HERTFORDSHIRE ECOLOGY

Application Engineering works comprising ground works and shaping of land to create a golf course (used only in conjunction with the Nyn Park Estate dwellinghouse) and erection of an associated single storey maintenance building

Address: Nyn Park, Well Road, Northaw, Potters Bar, EN6 4BS

Reference:6/2020/0311/MAJ

4.3 North Parkland Actions

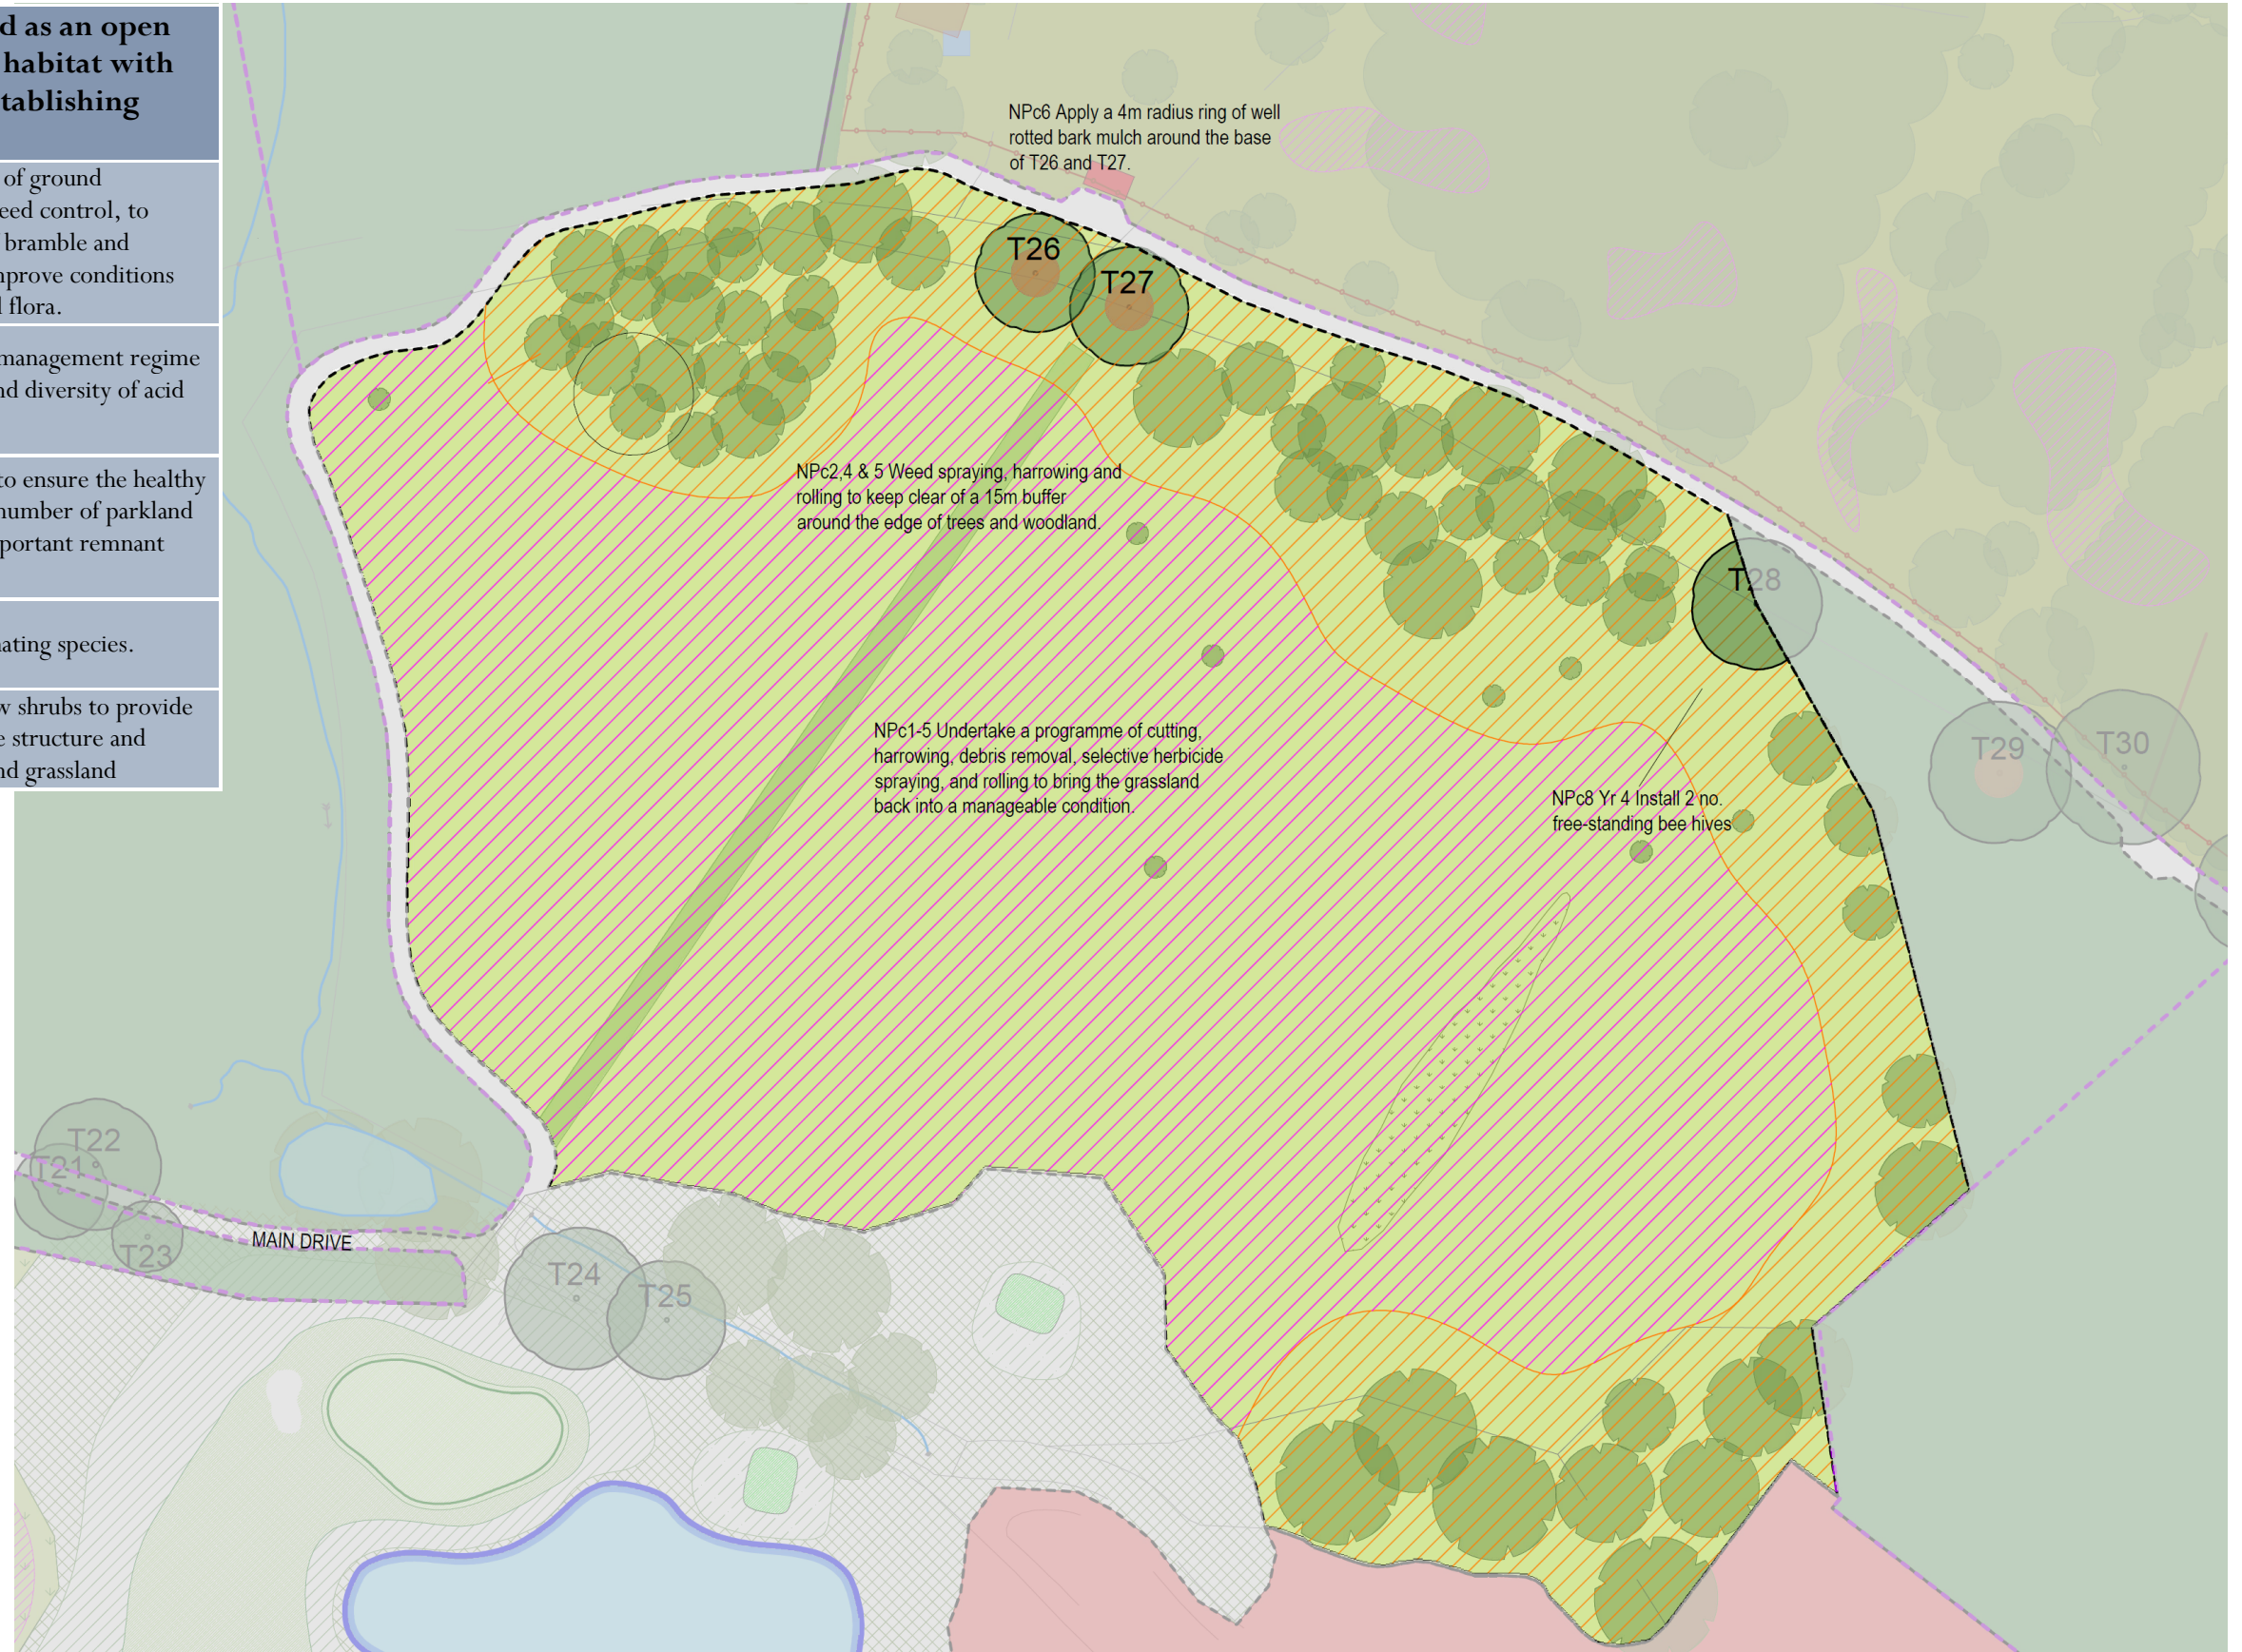
In this respect I am disappointed that proposals for the North Parkland do not involve grazing to help recreate and maintain acid grassland / heathland communities. The reason for this is that it is considered too close to the house. Why? In terms of traditional management this is a nonsense as farmhouses were often if not invariably surrounded by their managed land, and there is a large woodland belt which separates the grassland from the new country house.

I am also concerned that despite the presence of indicator species and description as species-rich grassland, it is proposed to herbicide the whole North Parkland compartment twice. A more natural approach to bramble, docks and thistle should be considered - especially as it obviously hasn't been managed effectively for ten years. Also, the ability to graze both the SSSI heathland and North Park areas is easy as they are adjacent to each other making a sensible and efficient approach to livestock management. Consequently, I advise the current proposals for this area should be reconsidered.

4.5 Well Wood Actions

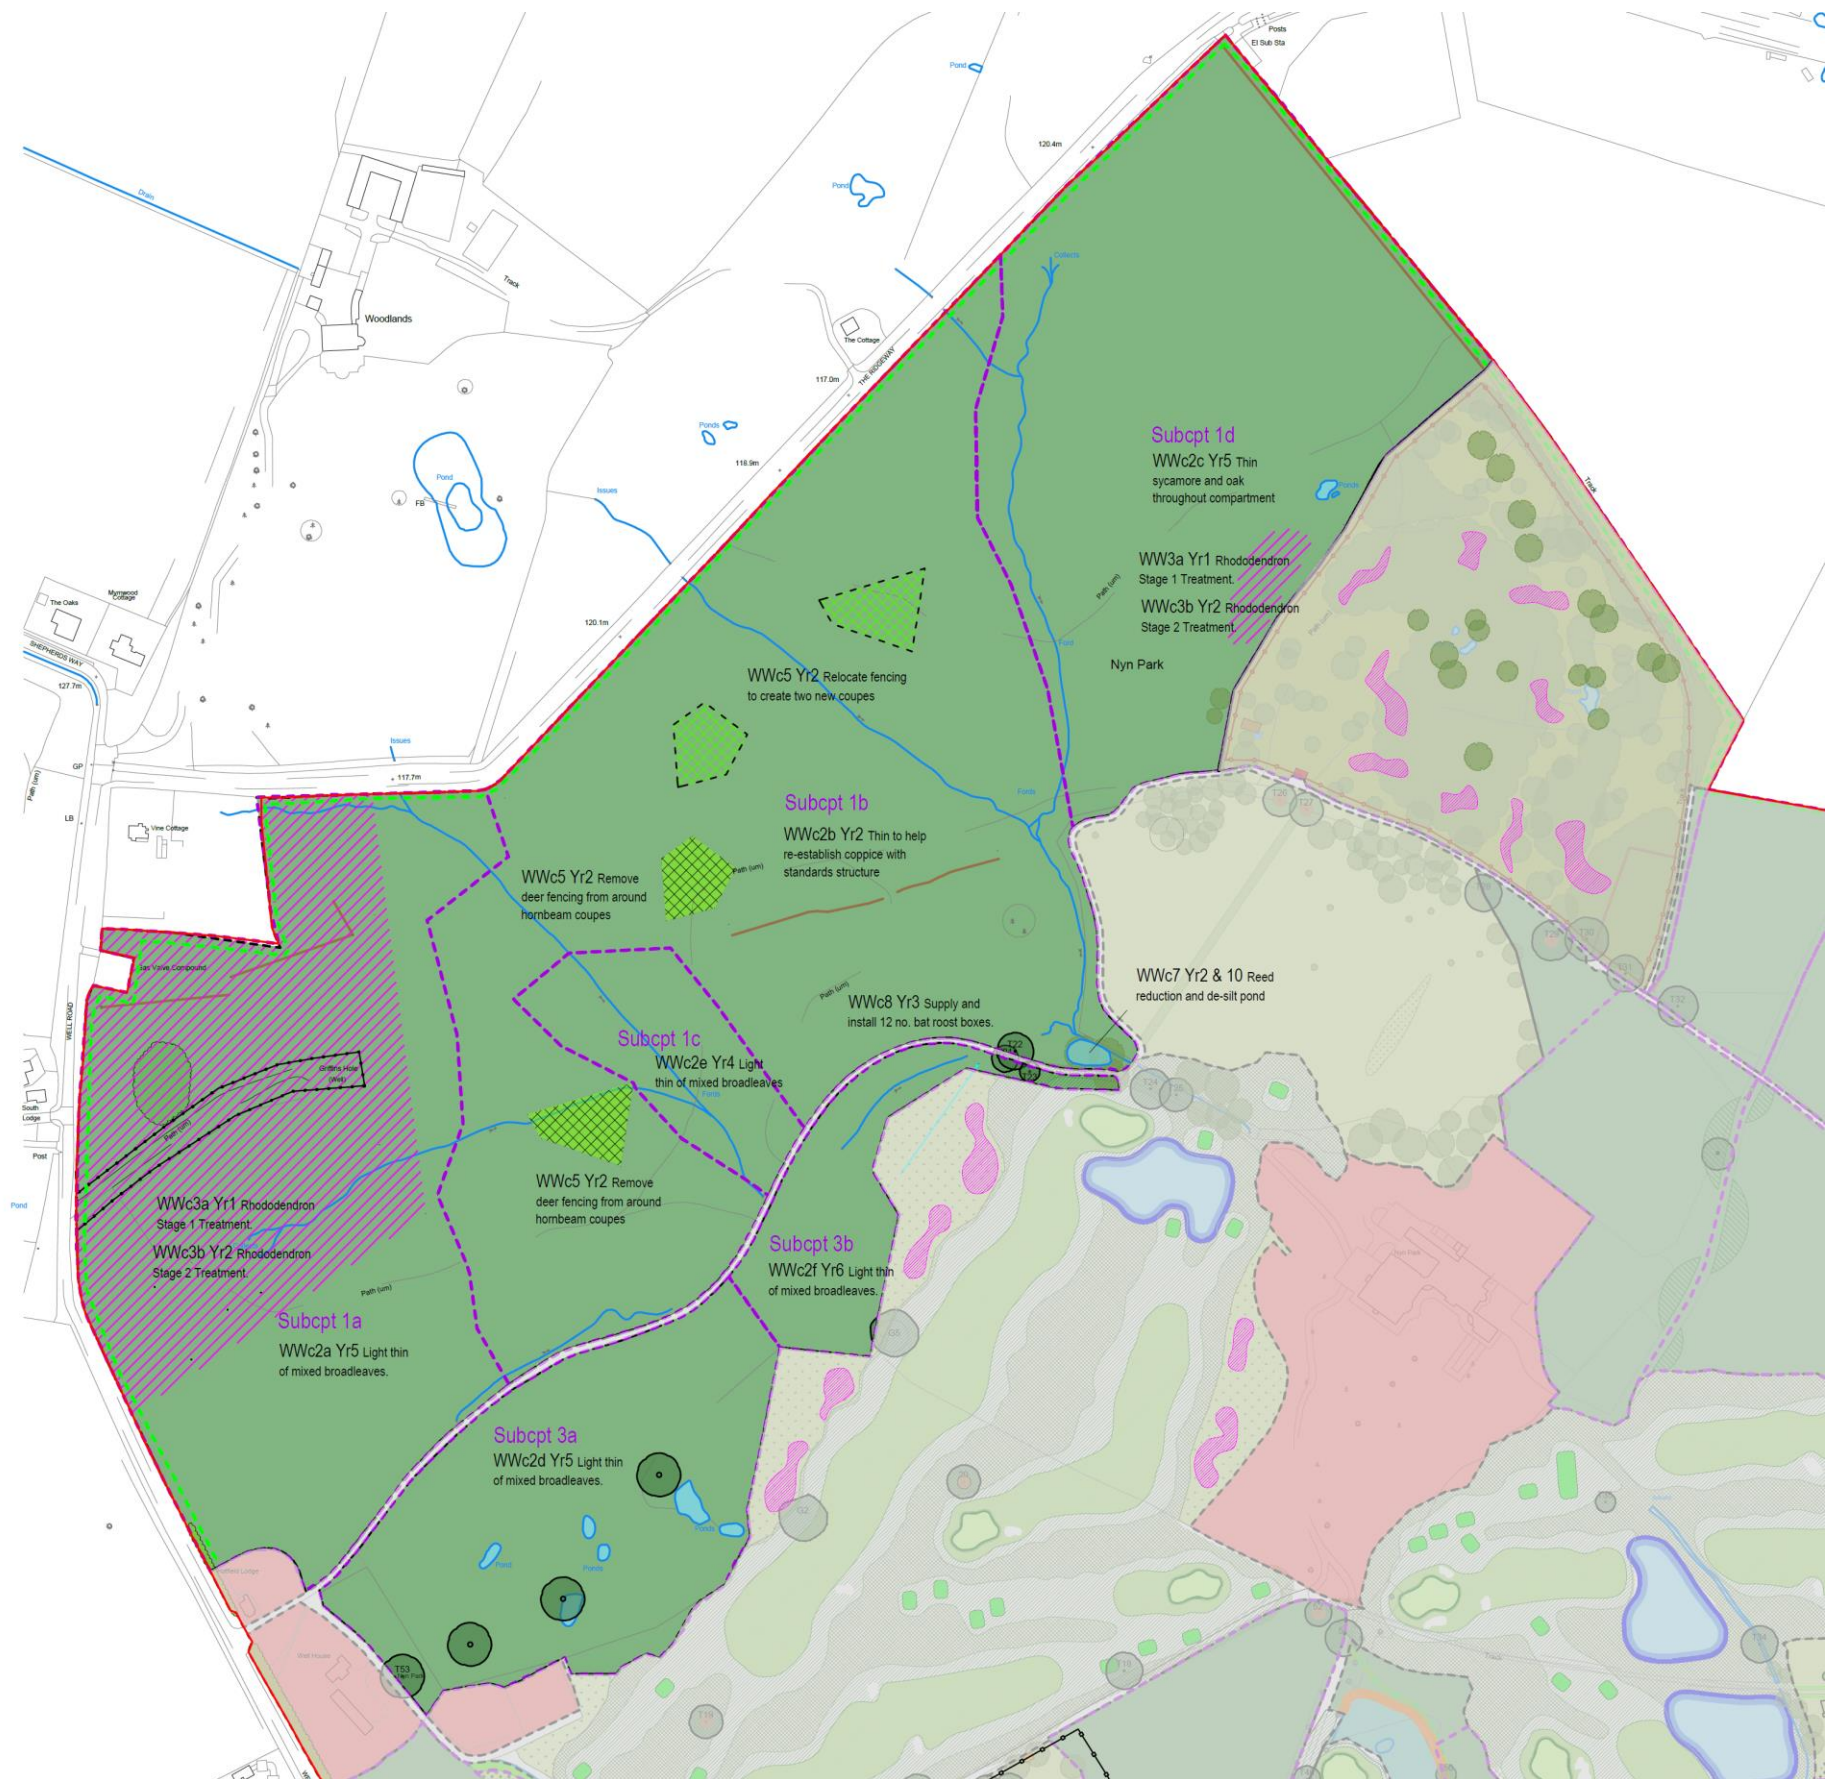
However, of this figure some 47 biodiversity units relate to improvements to Well Wood SSSI. One of the best practice principles of achieving net gain outlined by CIEEM is that it should achieve outcomes that do not include or exceed those resulting from existing obligations, such as those already relating to SSSIs, where a favourable condition should be sought. Consequently, measures for achieving this within the SSSI should not form part of the net gain calculations for this application. Despite this, when the metric is recalculated without the contribution of these sections, it still achieves a 11% habitat net gain.

Notwithstanding the need to calculate the net gain independent of the improvements to the SSSI, I acknowledge the need for a single management plan for the whole site that includes the SSSI given it lies within the same ownership. Furthermore, I support the measures outlined in this plan to bring about improvements to the SSSI which should return it to a favourable condition.
